Re: CHUZE Albuquerque
6600 Central Ave, SW
Albuquerque, NM 87121

Project Number: 21-6039-01
Permit Number: 2022-006777

Subject: Plan Check Correction List

ITEMS FROM CORRECTION LIST DATED 06/06/22:

**A001**

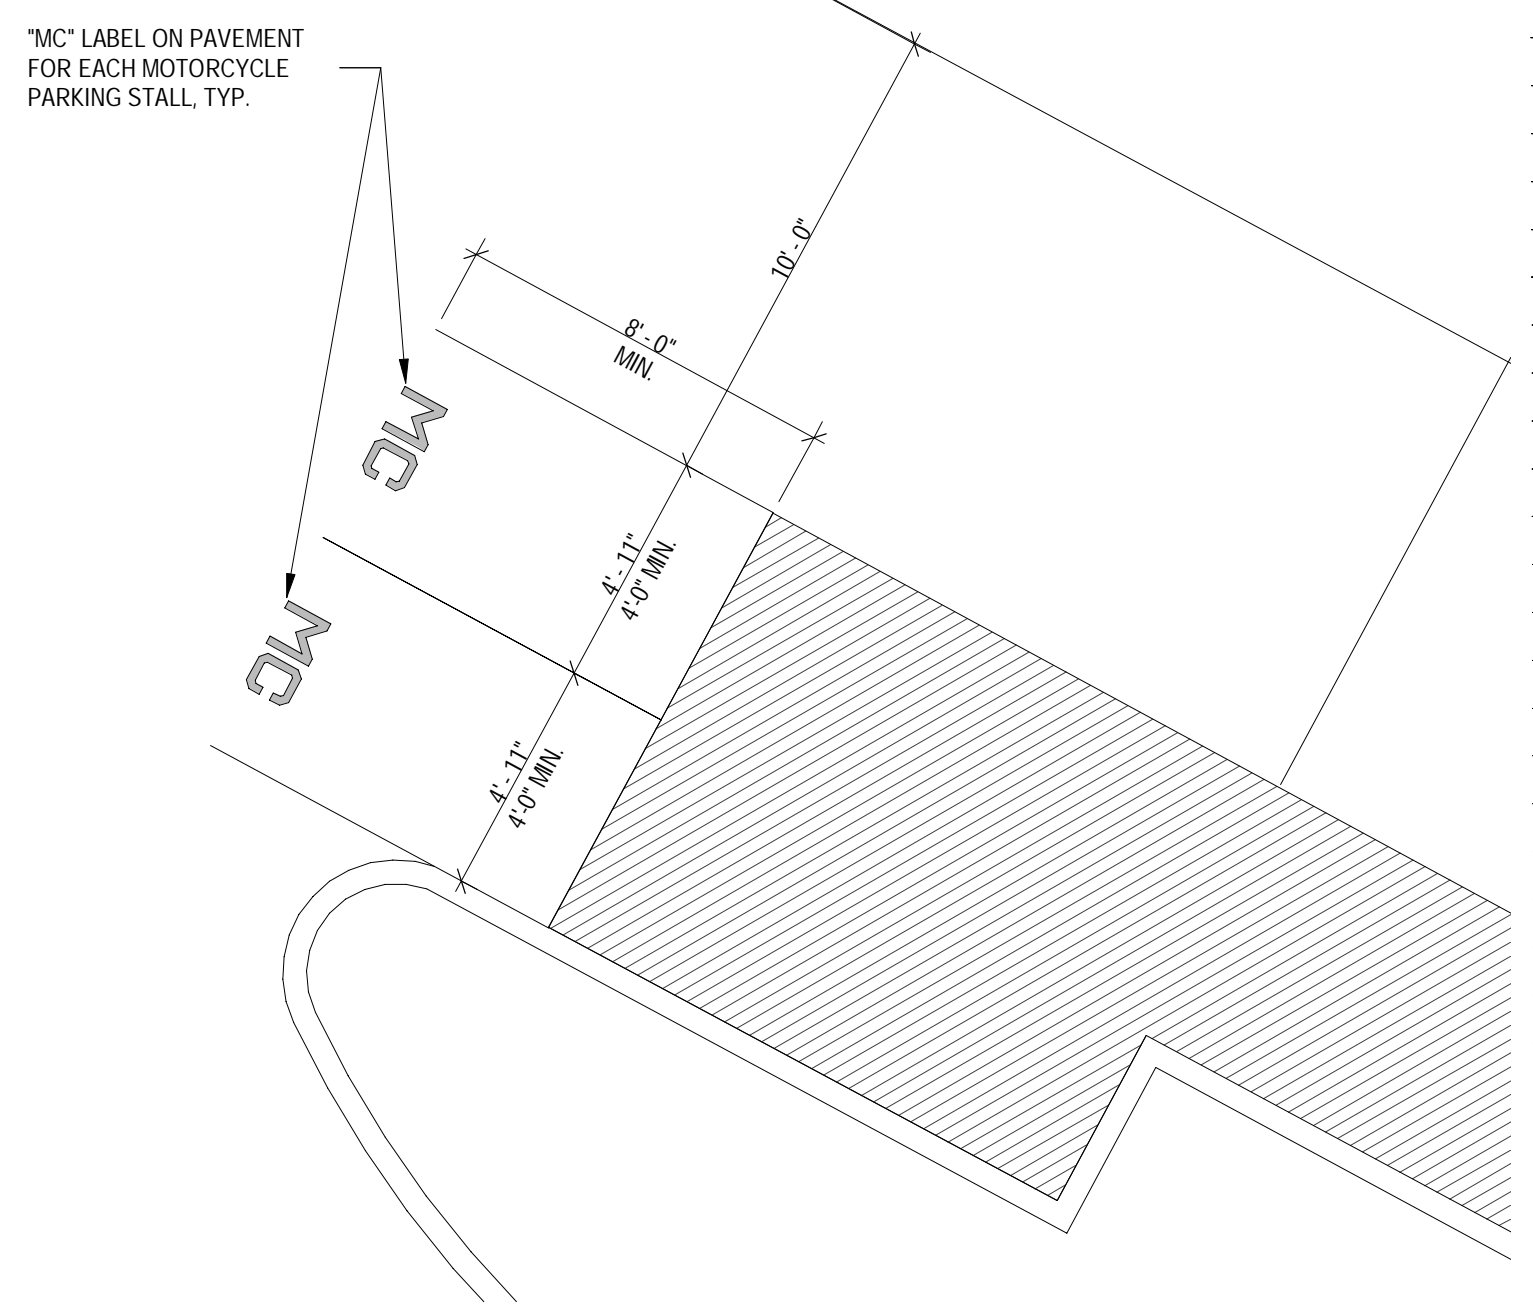
1. Provide parking calculation required by IDO for Motorcycle parking and for Bike Racks parking spaces.
Response: Motorcycle parking and Bike rack parking calculations have been added. Please see Sheet A001/ Parking Space Calculations – clouded Delta 7
2. Provide Motorcycles parking spaces dimensions and label "MC" on pavement for each parking space.
Response: Dimensions and label "MC" have been added to motorcycle parking spaces. Please see sheet A002.A/ Detail #15 Enlarged motorcycle parking space – clouded Delta 7
3. Provide Where is the Bike Rack key (note 19). Please show on site plan. See attached for new Bicycle rack requirements, it should be a horseshoe shape.
Response: Bicycle racks has been updated per DPM Section 7-4(K)(2): Bicycle Parking. Please see sheet A001/Keynotes #19; sheet A002.A/ Detail #13 and Detail #14 - clouded Delta 7

6. Show on sight plan the Intersection Sight Distance for Coors Blvd. see attached

Response: Intersection Sight Distance has been added for Coors Blvd. Please see sheet A001/Detail #2 – clouded Delta 7

8. Add a note stating, "All broken or cracked sidewalk must be replaced with sidewalk and curb & gutter."

A build note must be provided referring to the appropriate City Standard drawing.

Response: Note has been added. Please see sheet A001/ Note #3 – clouded Delta 7
